## SSD 7684 – COCKLE BAY, FURTHER INFORMATION REQUEST

We refer to your emails of 17 August 2018 and 6 September 2018 requesting additional information in relation to the above SSD application. A consolidated response to your queries are provided in the below table.

**14.5m BUS VEHICLE SWEEP  
 PATHS**

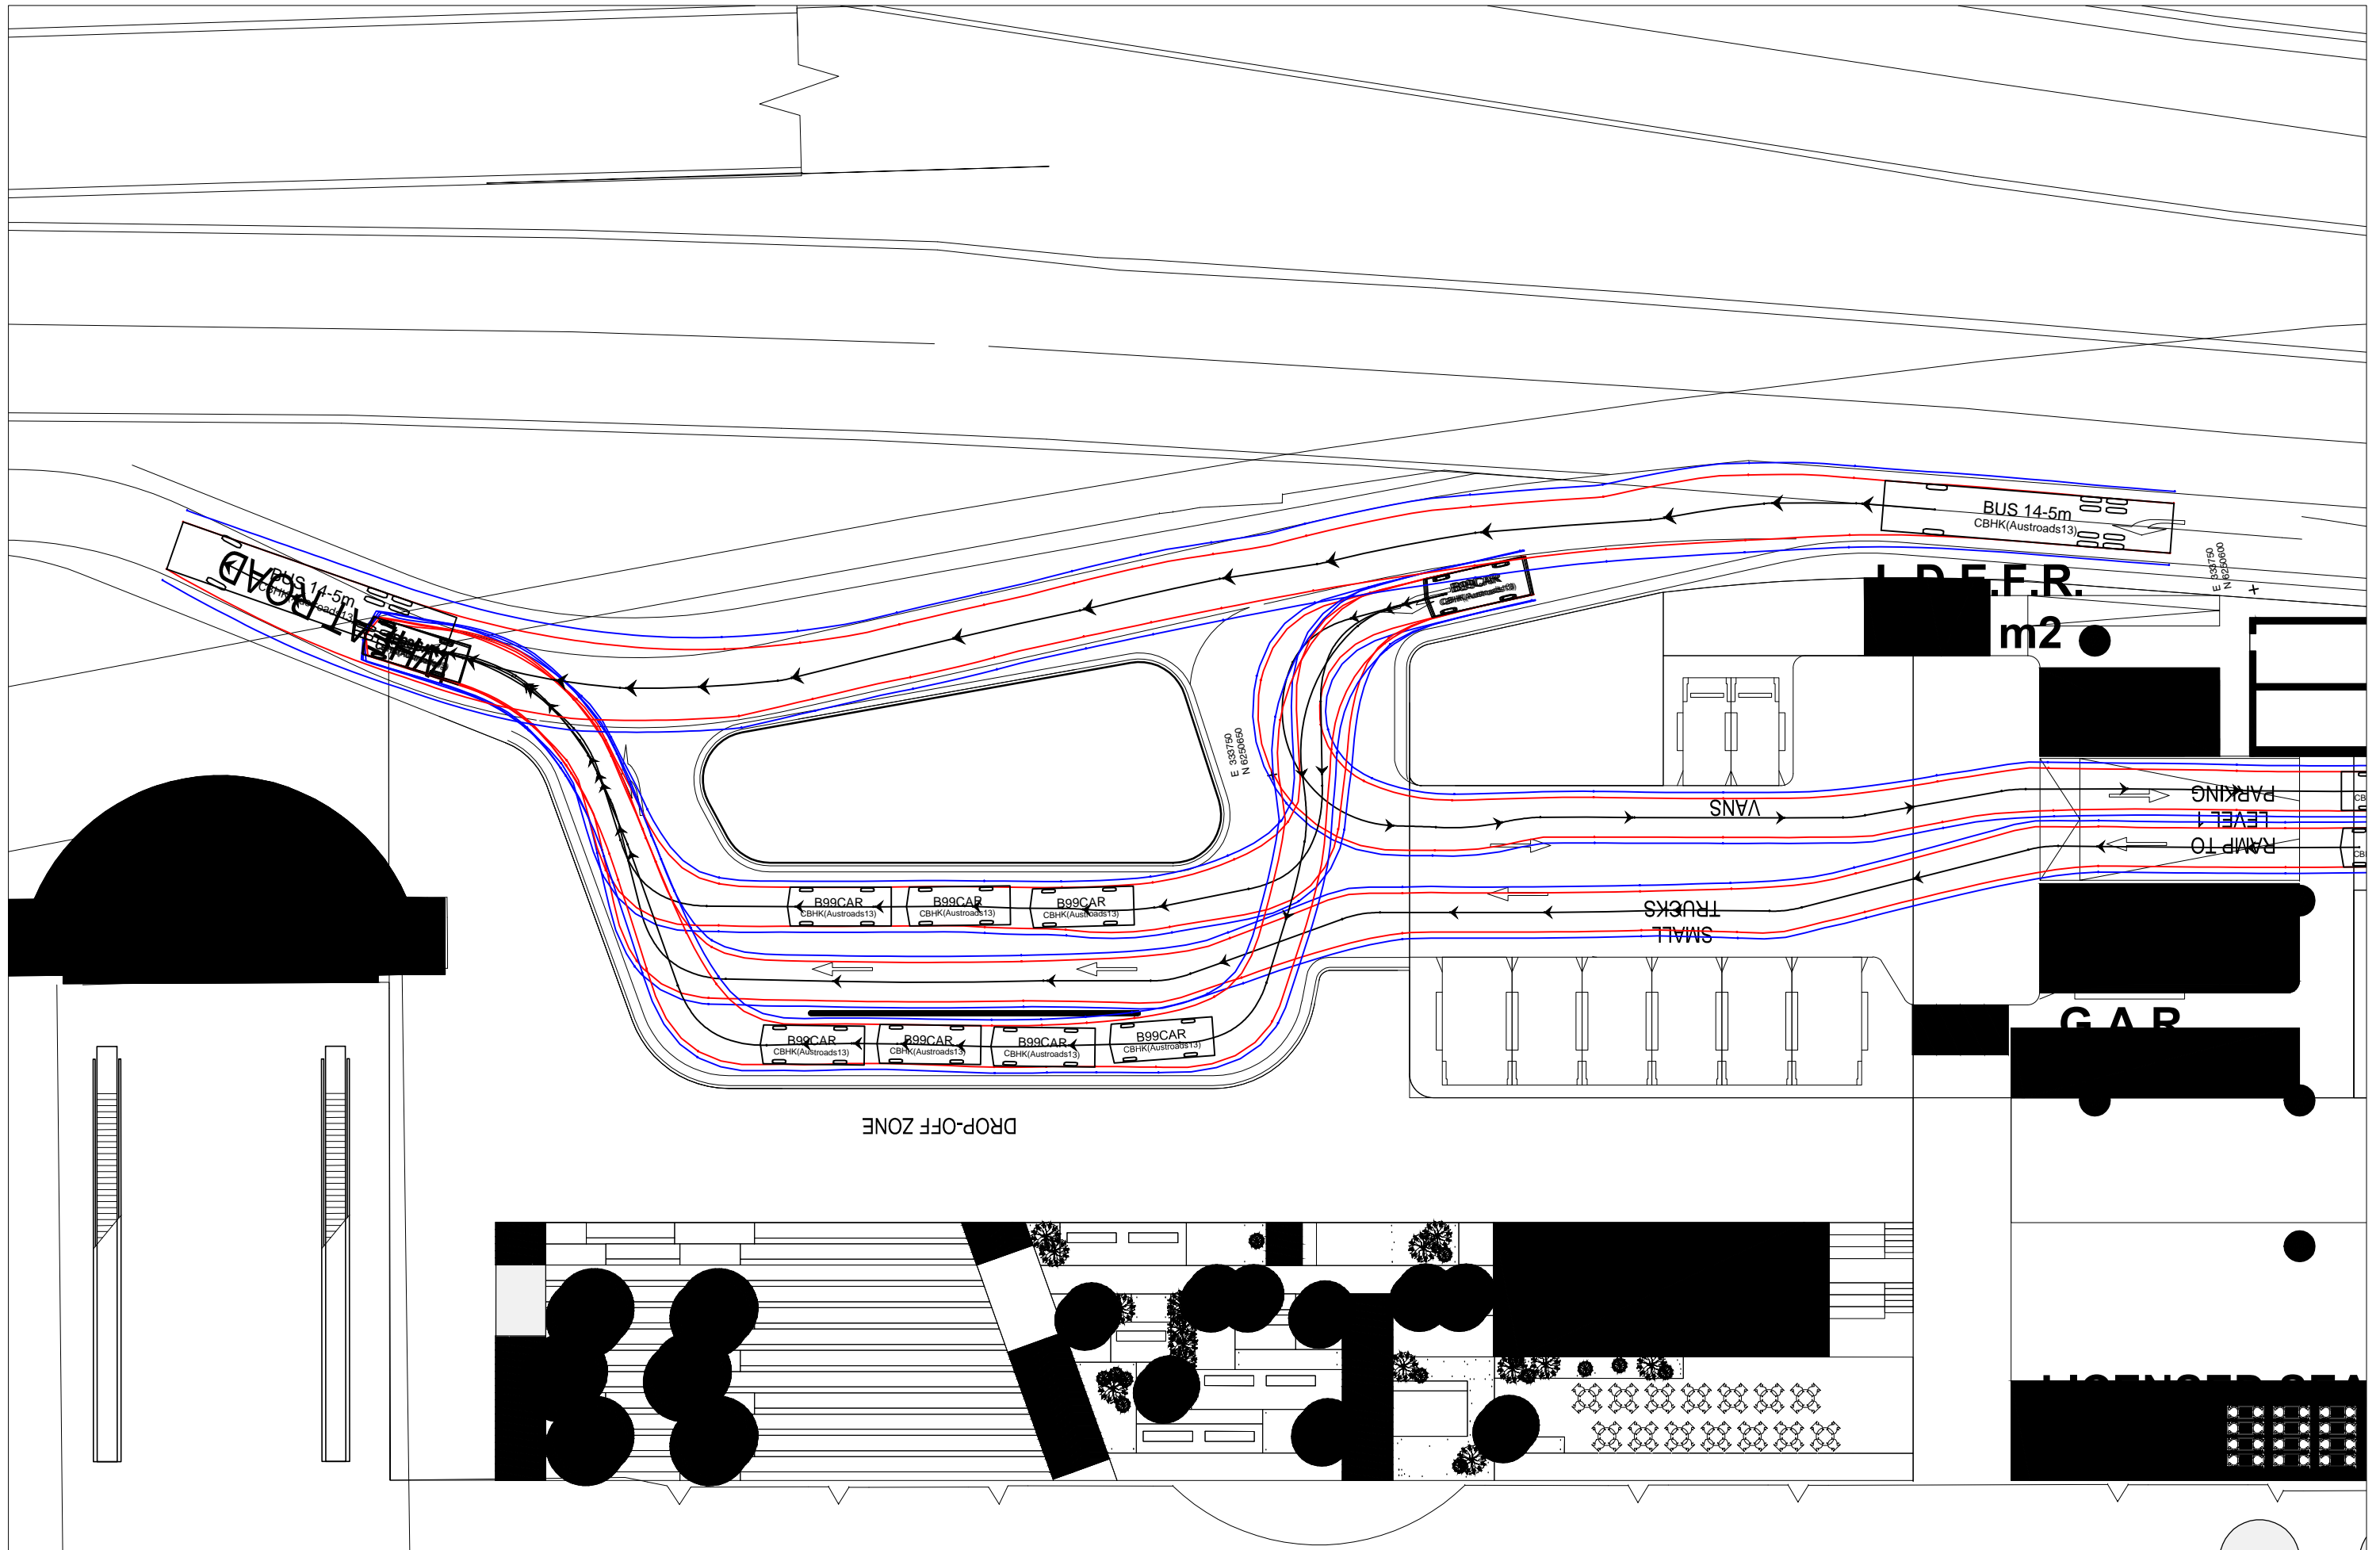
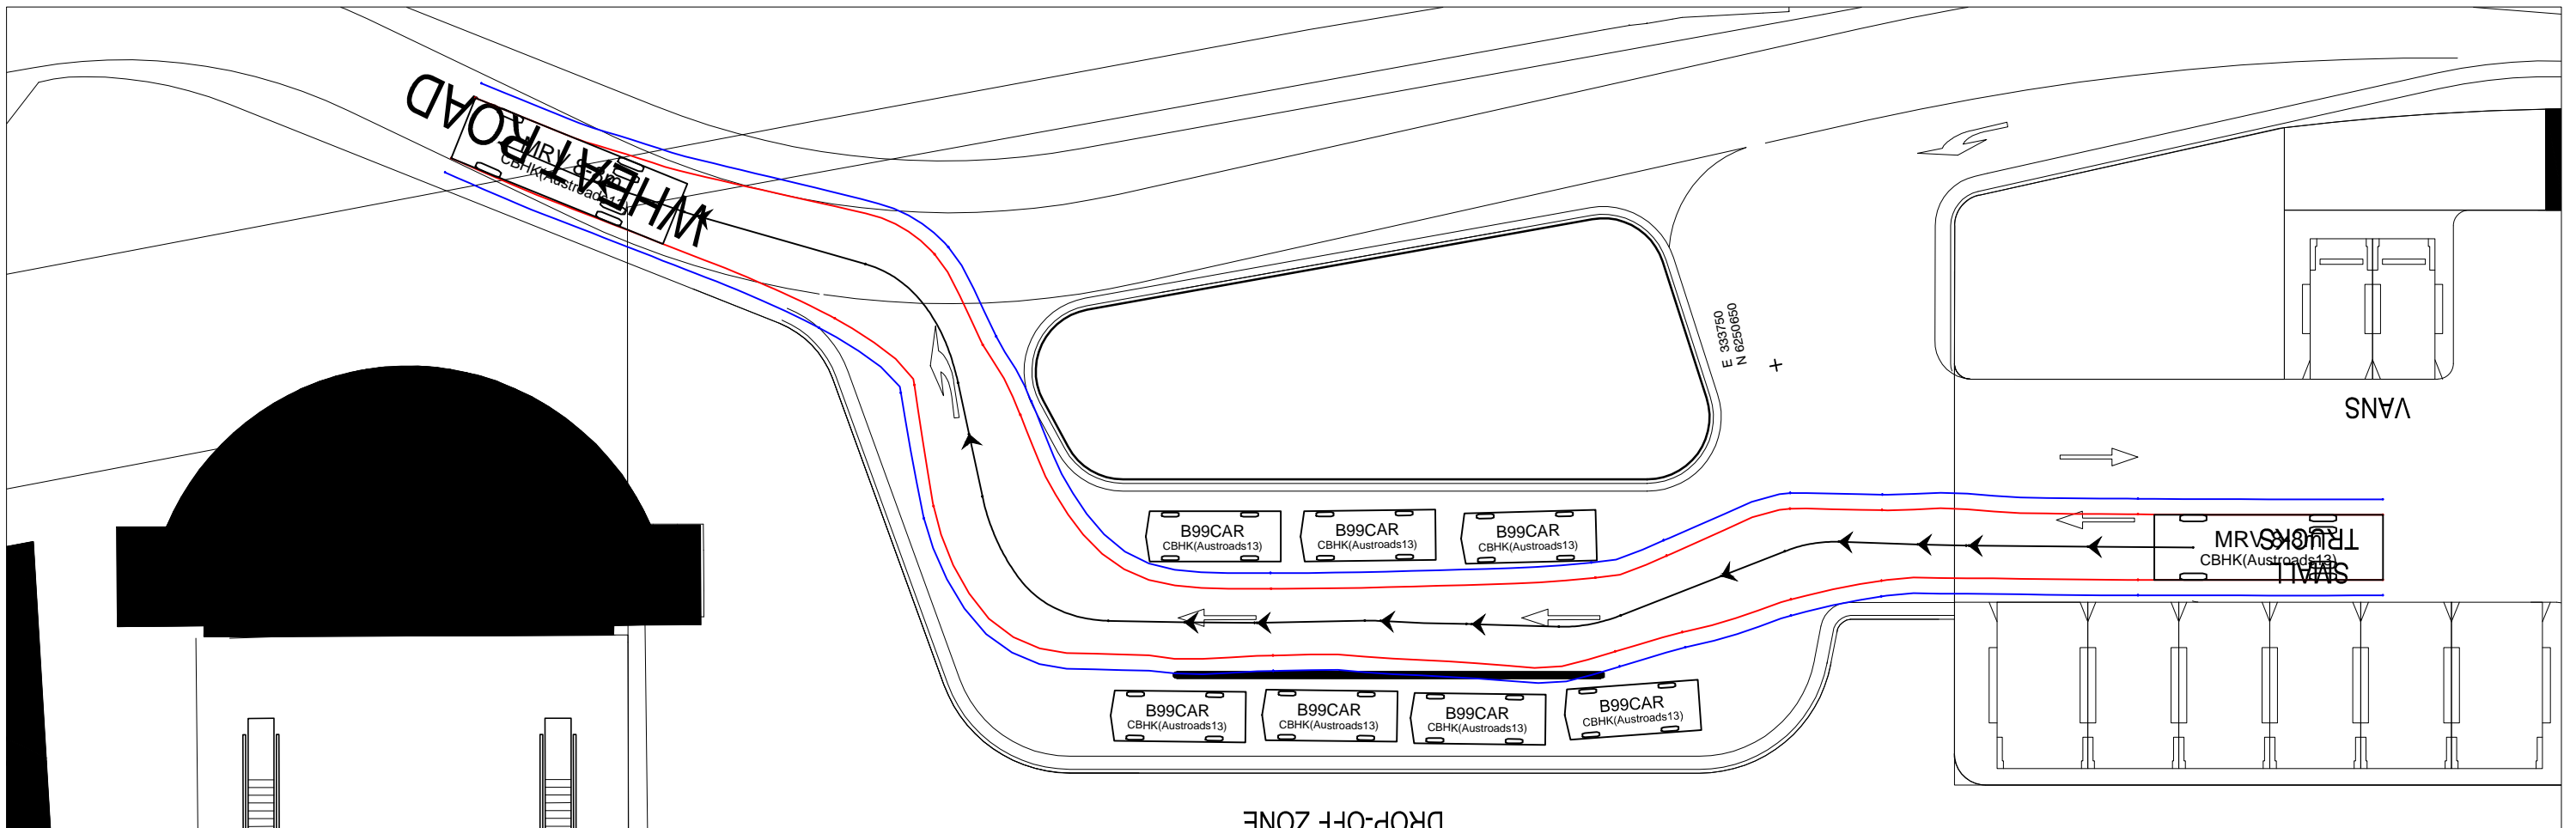
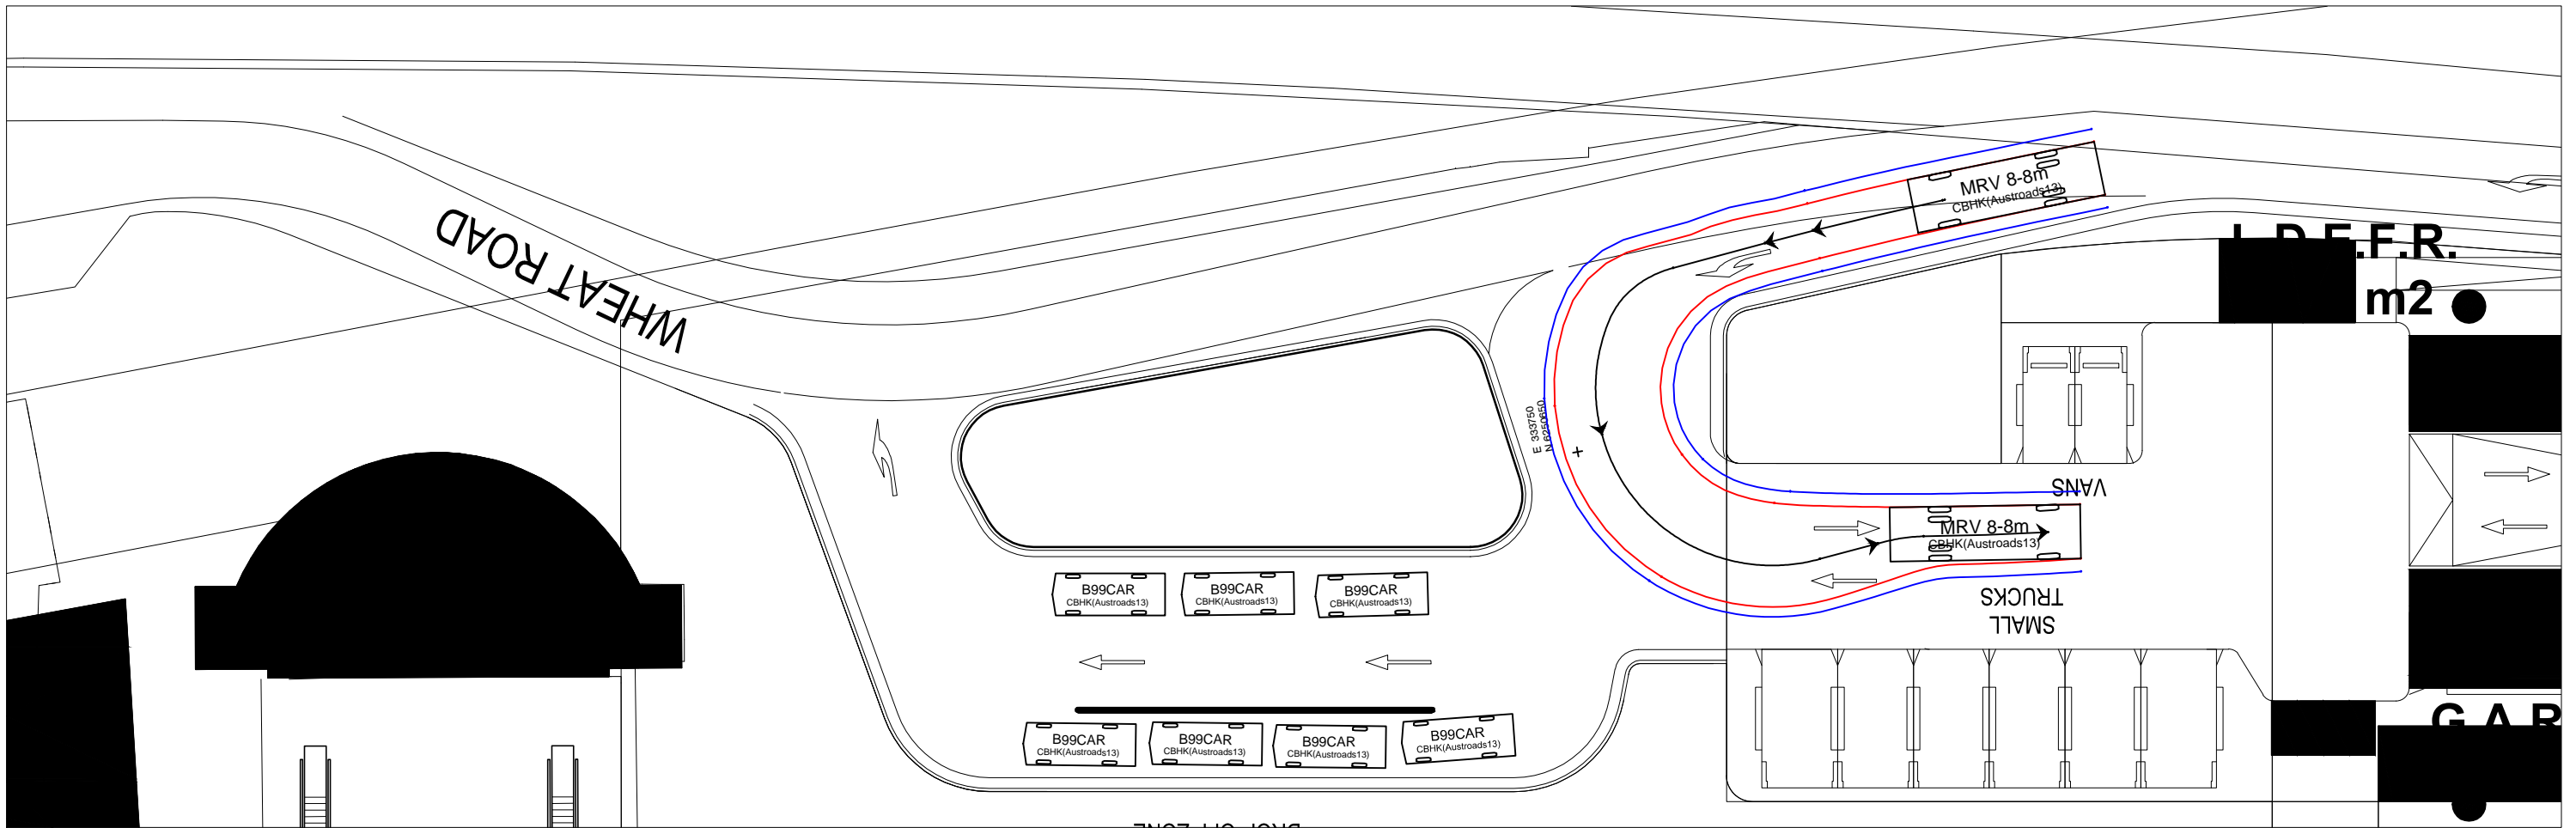
8	Provide updated vehicle swept path analysis for the southern access. It is noted the current diagrams relate to 'Base Case + Option 2', which is no longer proposed	An updated vehicle swept path 'Base Case' and 'Option 1' has been prepared by Aurecon and is provided at <b>Appendix C</b> .
9	Provide evidence the proposal does not conflict with the approved updated design of the IMAX port cochere.	<p>Please refer to the civil plans prepared by Aurecon at <b>Appendix C</b>.</p> <p>It is noted that Interface Design meetings were held with The Ribbon on the following dates 29/8/2017, 6/9/2017 and 29/9/2017 at The Ribbon's Site office.</p> <p>It is noted that both options proposed for the southern entry of the site align with current approved designs for the vehicular entrances of The Ribbon. Co-ordination has been conducted using Drawing no. ARC-HSL-DD-1100 RevN1, this being the latest stamped drawing for The Ribbon, dated 20/10/2017 stamped on the 2/11/2017 for MOD 3 SSD7388.</p>
